Housing Delivery Authority – Major Projects 300 Burns Bay Road Lane Cove (SSD- 87925706)

Attention Gabriel Kim,
Department of Planning, Housing and Infrastructure

Thank you for the opportunity for Lane Cove Council to comment on the redevelopment and rezoning proposal for the site at 300 Burns Bay Road.

Figure 2.7 – Level 2-6 plan

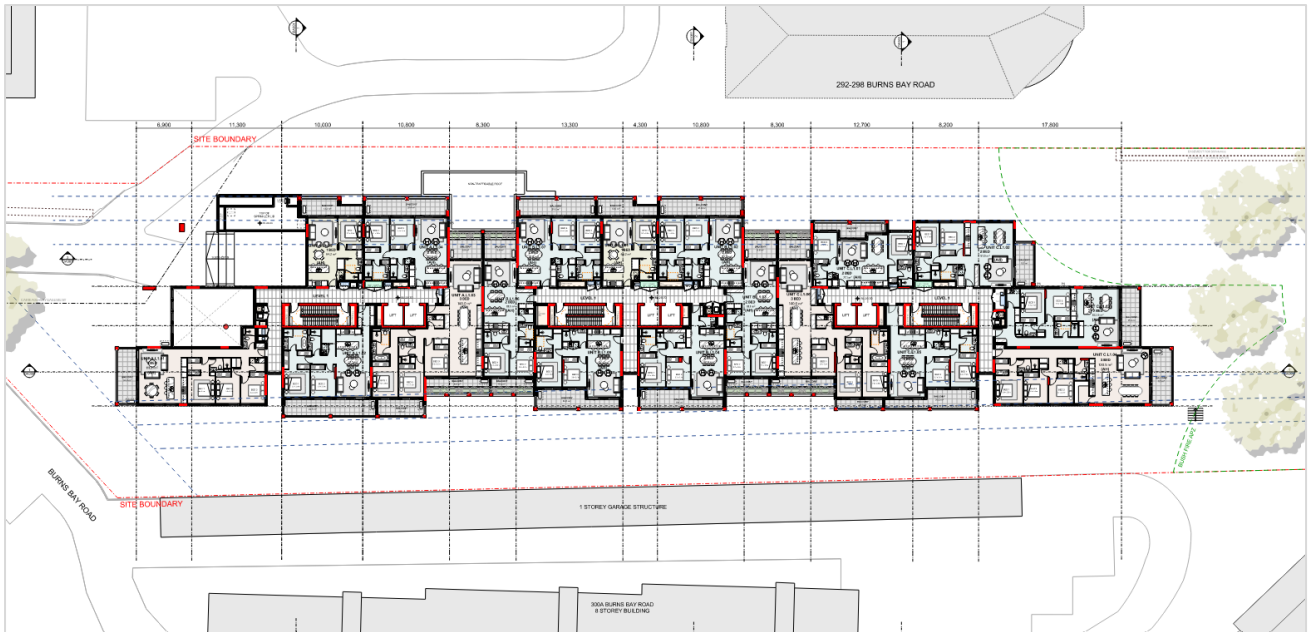
The proposed setback for the north elevation of tower B does not comply. Including the northern balconies being setback approximately 5.6m, and glass line of the internal spaces being setback approximately 8.4m. (Refer to figures 9 and 9A below). The lack of building separation would result in adverse privacy/overlooking impacts between the south-facing units of 292-298 Burns Bay Road and north-facing units of the subject site.

Comment: The proposal fails to comply with Section 3F Building Separation in the ADG.
